**PLANNING DEPARTMENT
DEVELOPMENT SERVICES DIVISION
600 2nd Street NW, Ground Floor, 87102
P.O. Box 1293, Albuquerque, NM 87103
Office (505) 924-3946**

OFFICIAL NOTIFICATION OF DECISION

Project# PR-2020-003484
Application#
SD-2023-00048 – PRELIMINARY PLAT

For all or a portion of
**Lots 2 & 3, Block 12 Unit 3, VOLCANO
CLIFFS SUBD** zoned **R1-D** located on **Mojave
Street NW between Unser and Tesuque**
containing approximately **4.25** acre(s).
(L-10)

PRELIMINARY PLAT FOR
MOJAVE RIDGE SUBDIVISION
 (A REPLAT OF LOTS 2 & 3, BLOCK 12,
 UNIT 3, VOLCANO CLIFFS SUBDIVISION)
 WITHIN
 SECTION 27,
 TOWNSHIP 11 NORTH, RANGE 2 EAST, N.M.P.M.
 CITY OF ALBUQUERQUE
 BERNALILLO COUNTY, NEW MEXICO
 JANUARY, 2023

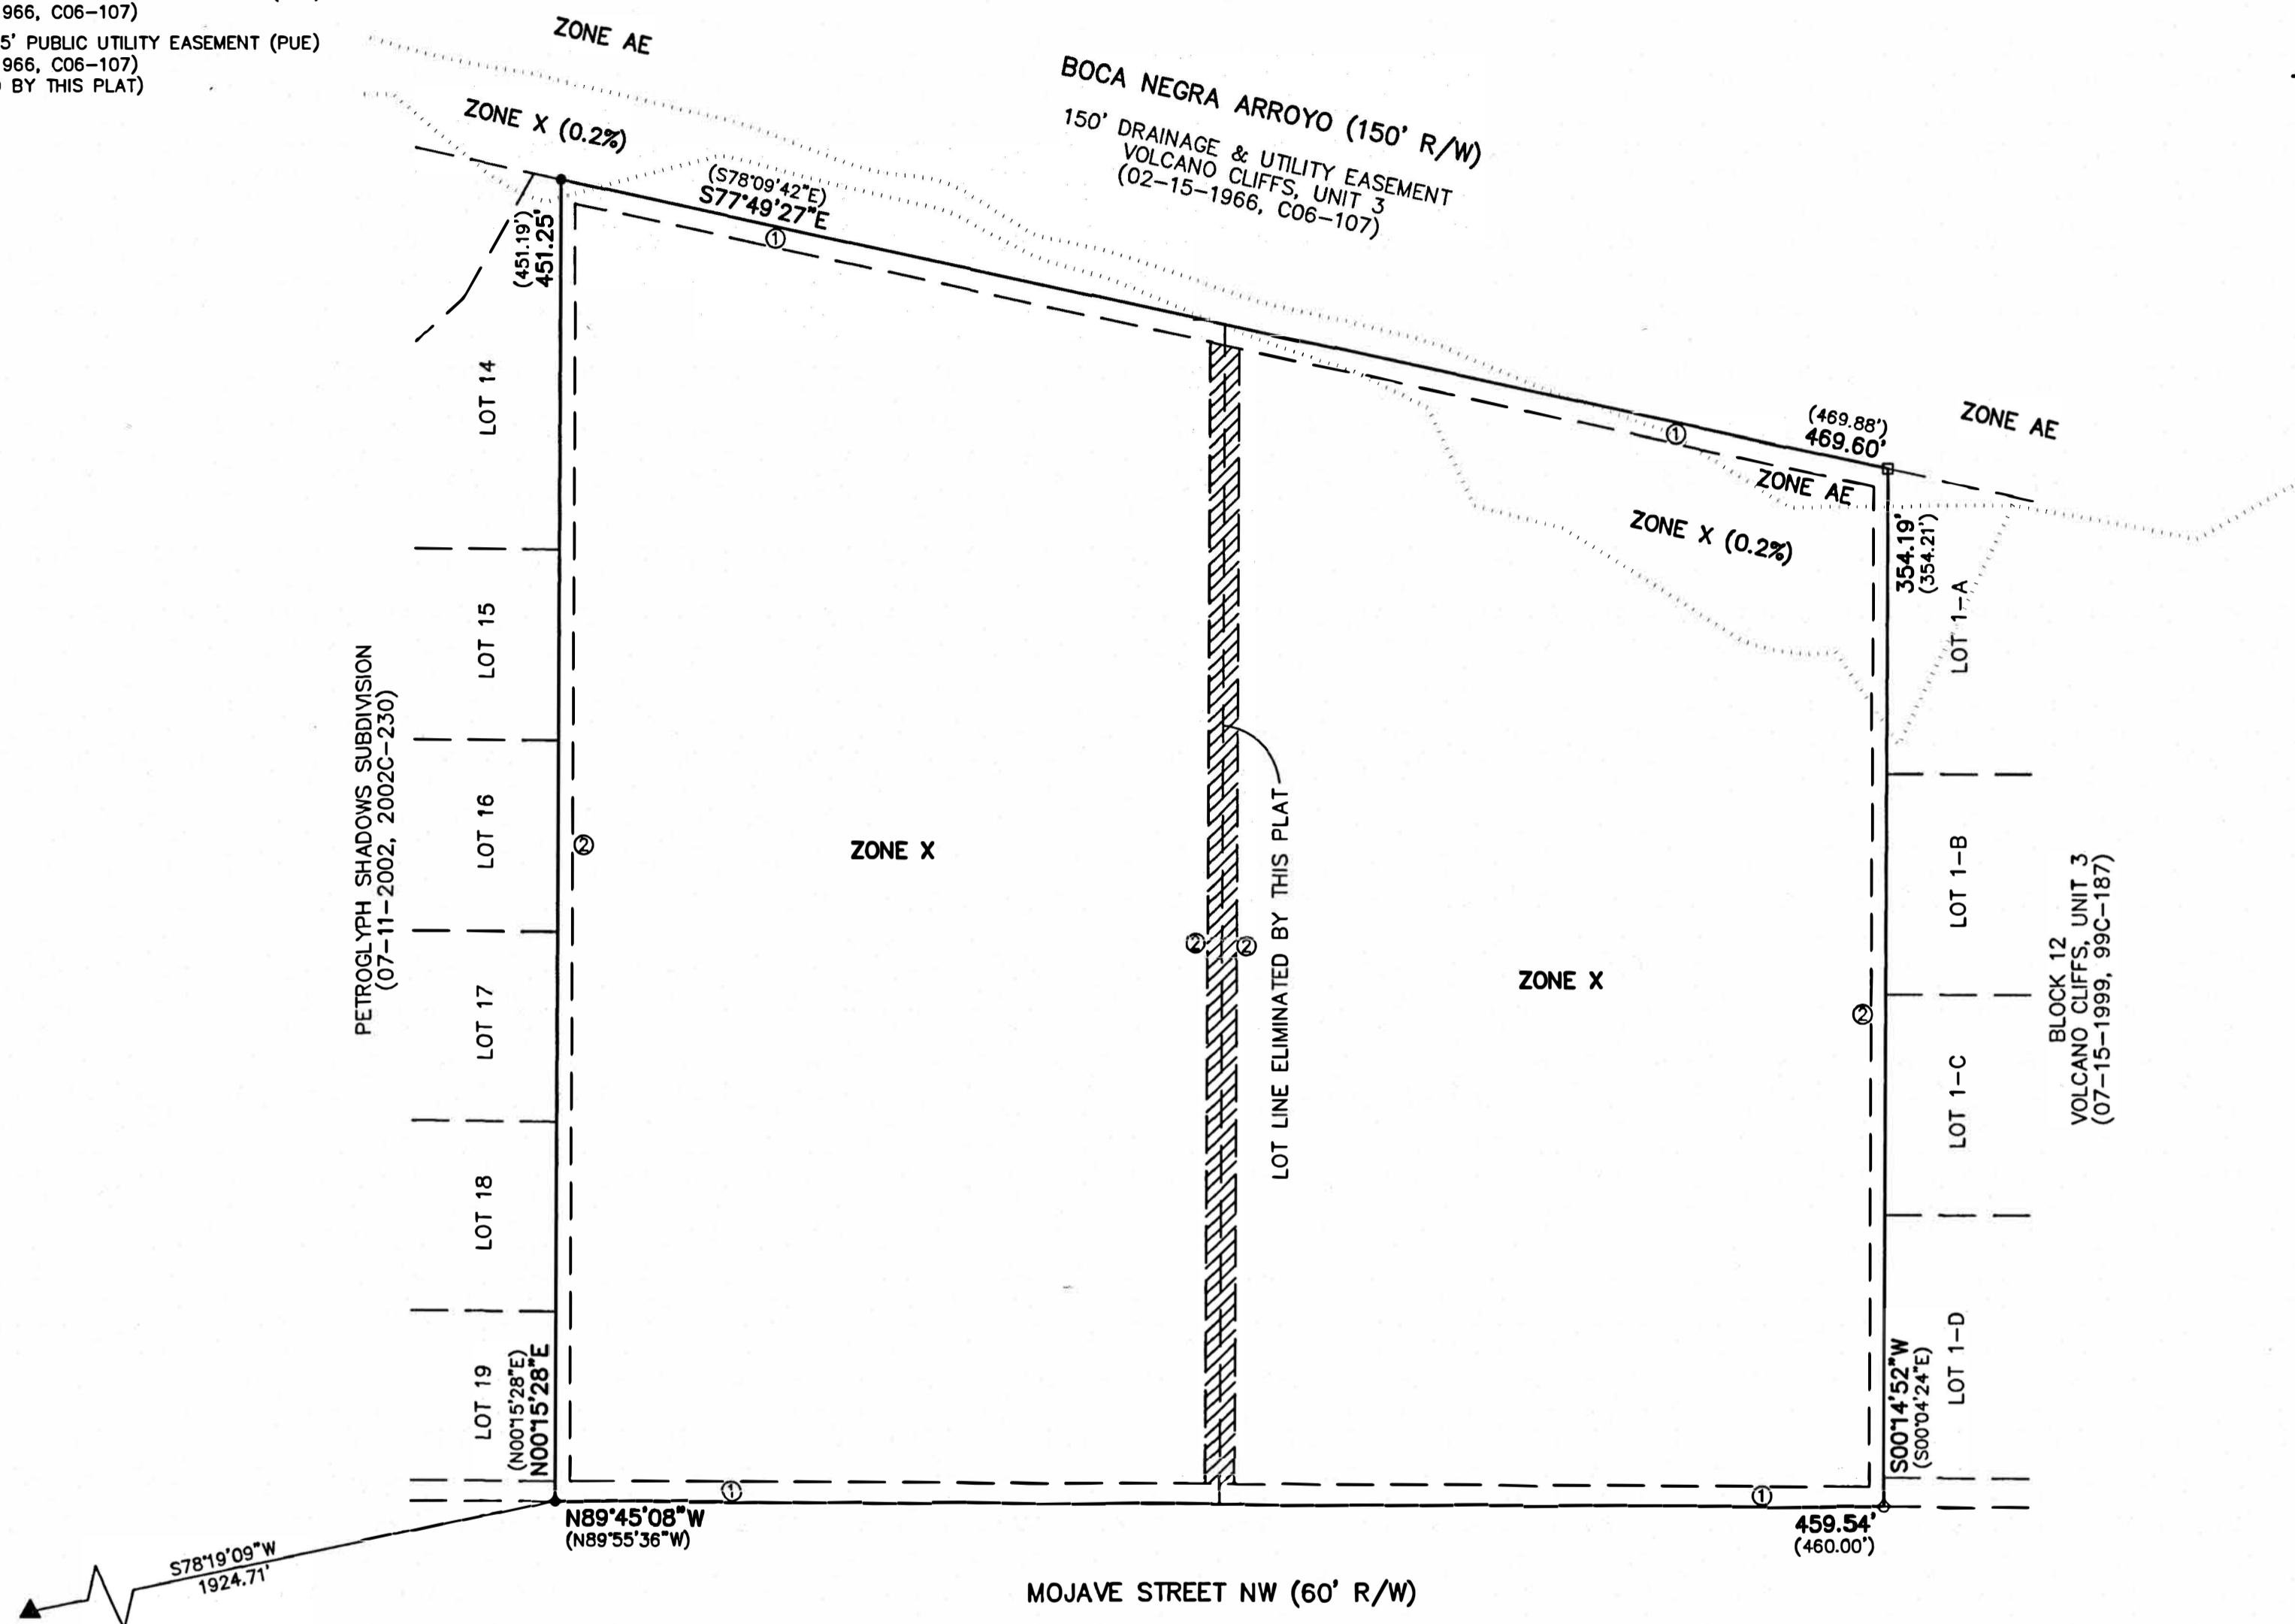
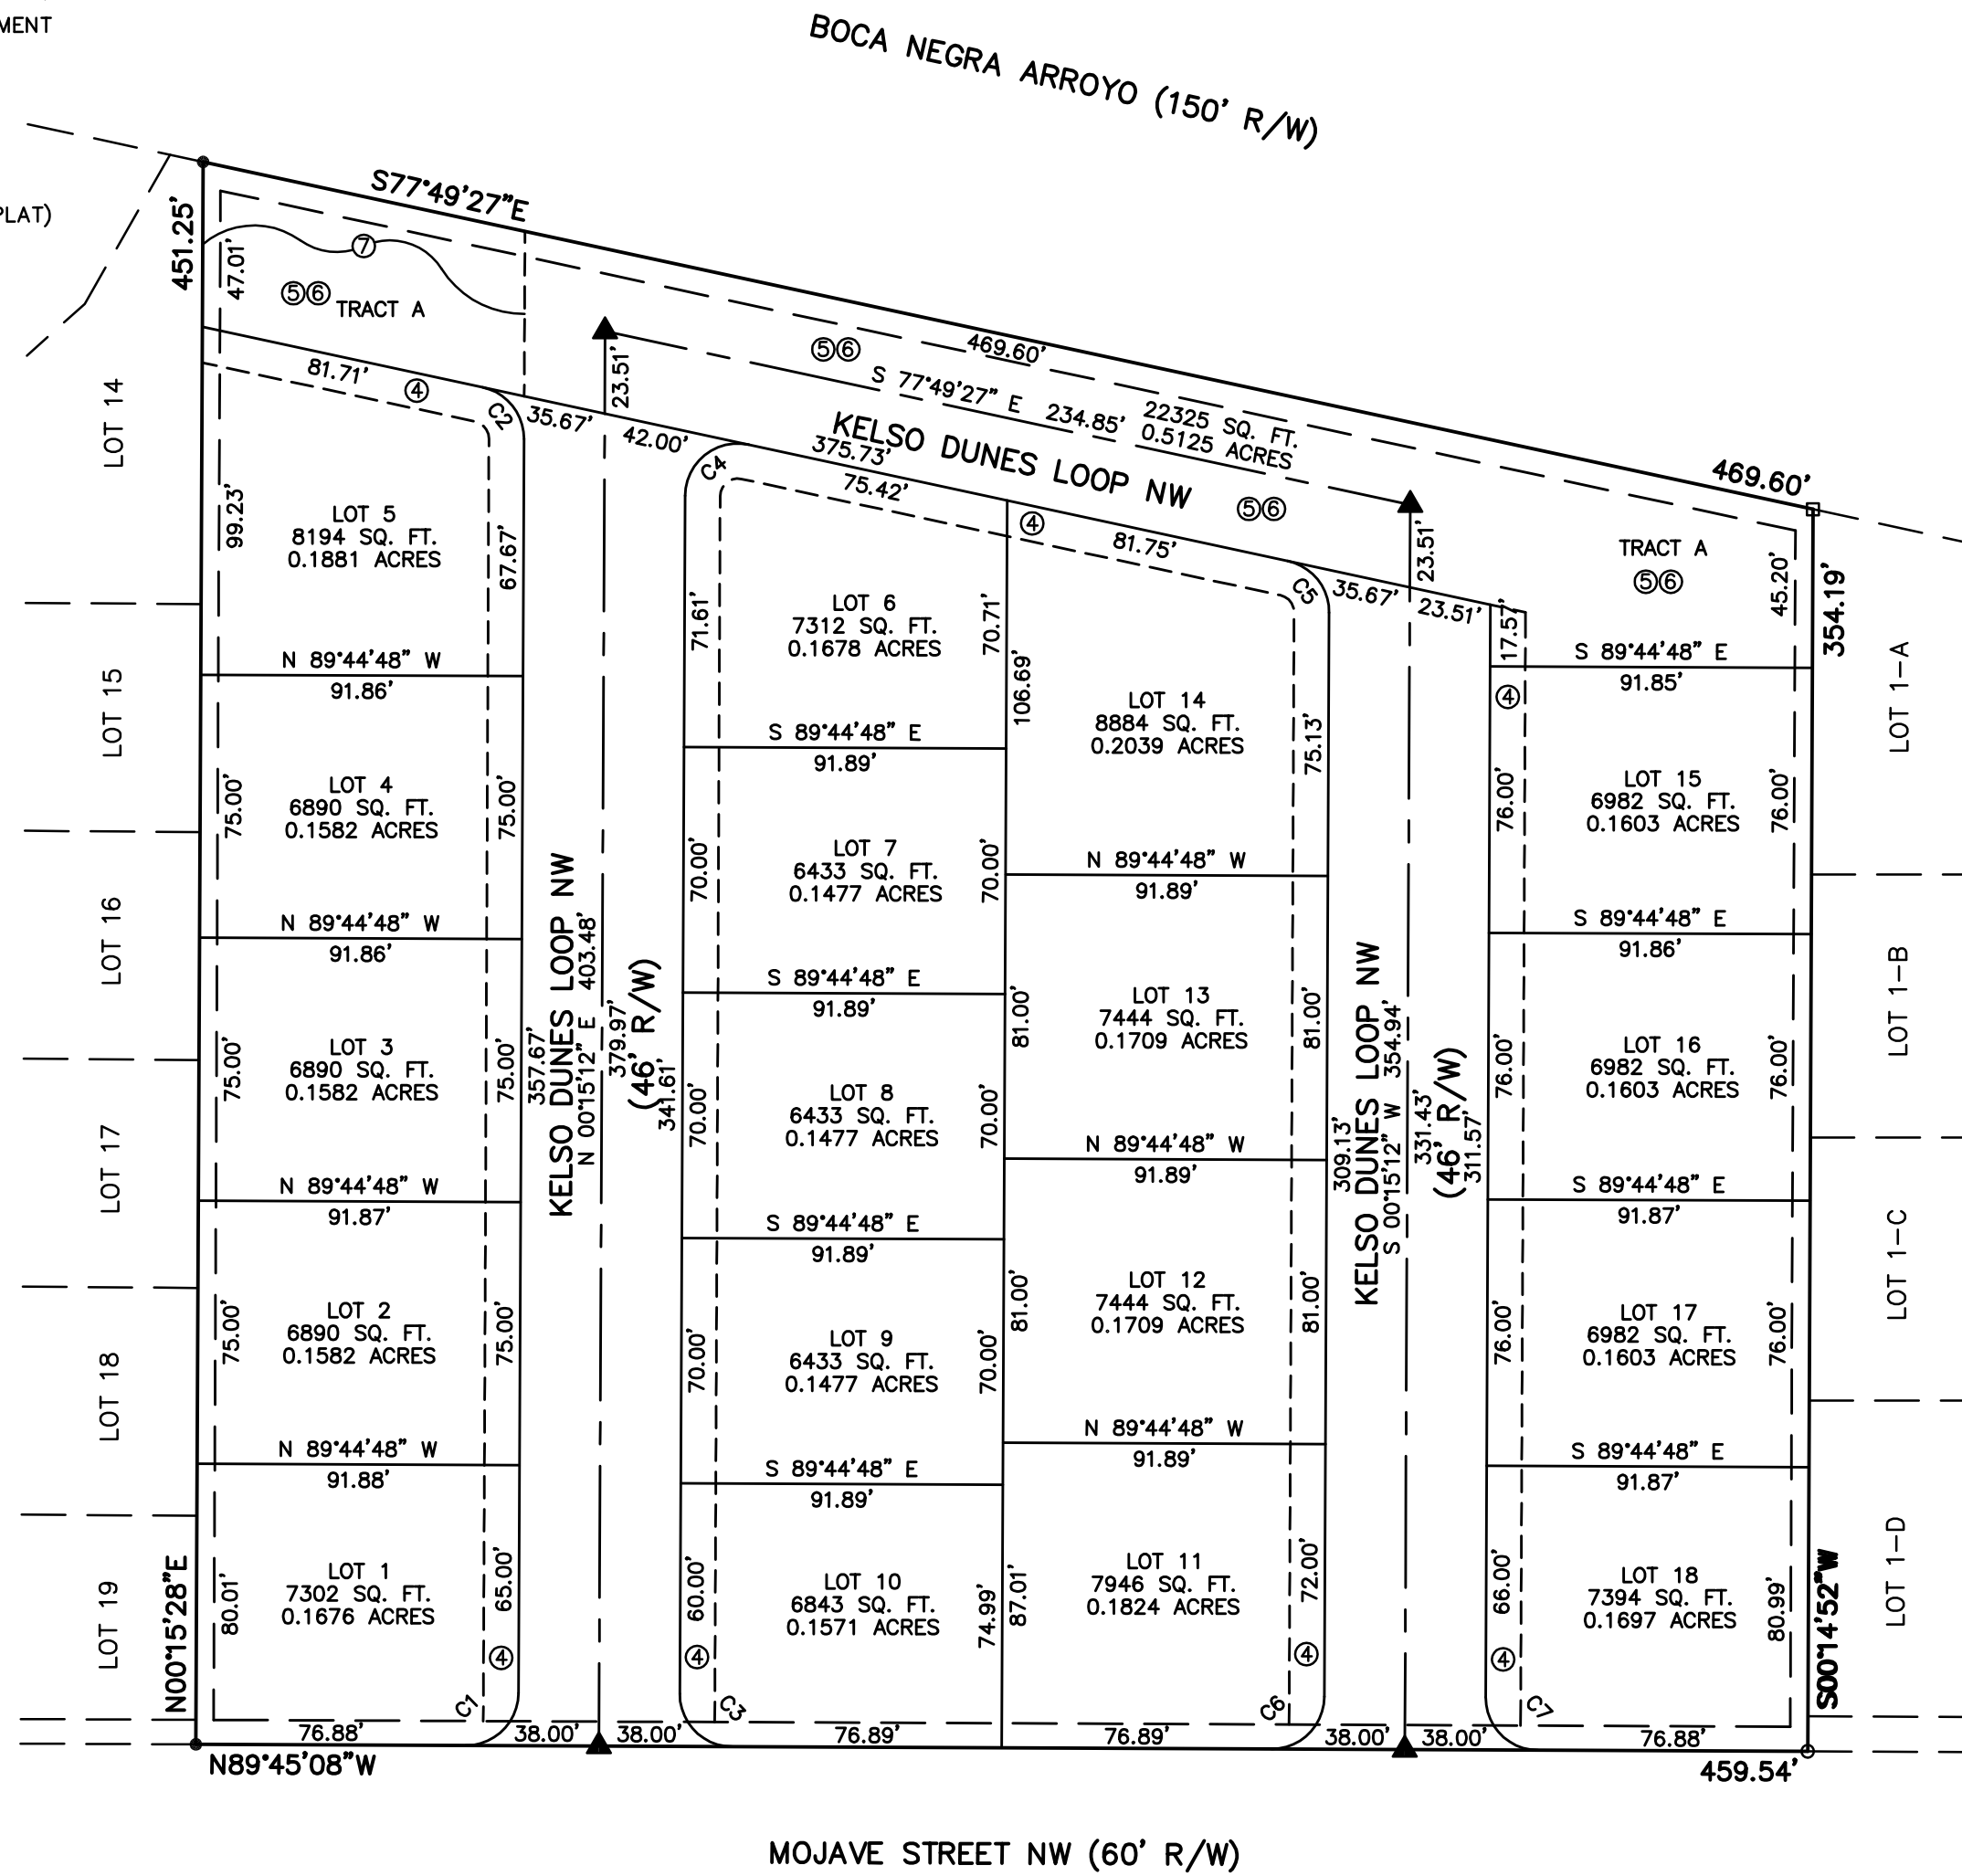
- a. Per ABCWUA: Add the following note to the Cover of the: 'ABCWUA Public Water & Sanitary Sewer Easements Albuquerque Bernalillo County Water Utility Authority (ABCWUA) is granted perpetual, exclusive easement(s) in gross in the dimensions noted on this plat for the construction, installation, maintenance, repair, modification, replacement and operation of public water and sanitary lines, equipment and facilities reasonably necessary to provide service together with free access on and over the easement and the right to remove trees, shrubs, undergrowth and any other obstacles, modifications, or structures which interfere with use of the easement.'

- b. Per Parks and Recreation: Add note on the plat that the parcel adjacent to the subject site "Boca Negra Arroyo (150' R/W)" is zoned NR-PO-B for MAJOR PUBLIC OPEN SPACE - PETROGLYPH NATIONAL MONUMENT.

- c. Per Planning: Revise the Infrastructure List Notes on Drainage to state 'City Standard Specification 1013.' Add a note to the Plat indicating DHO approval of the determination to retain a 60 foot Right-of-Way on Mojave Street.
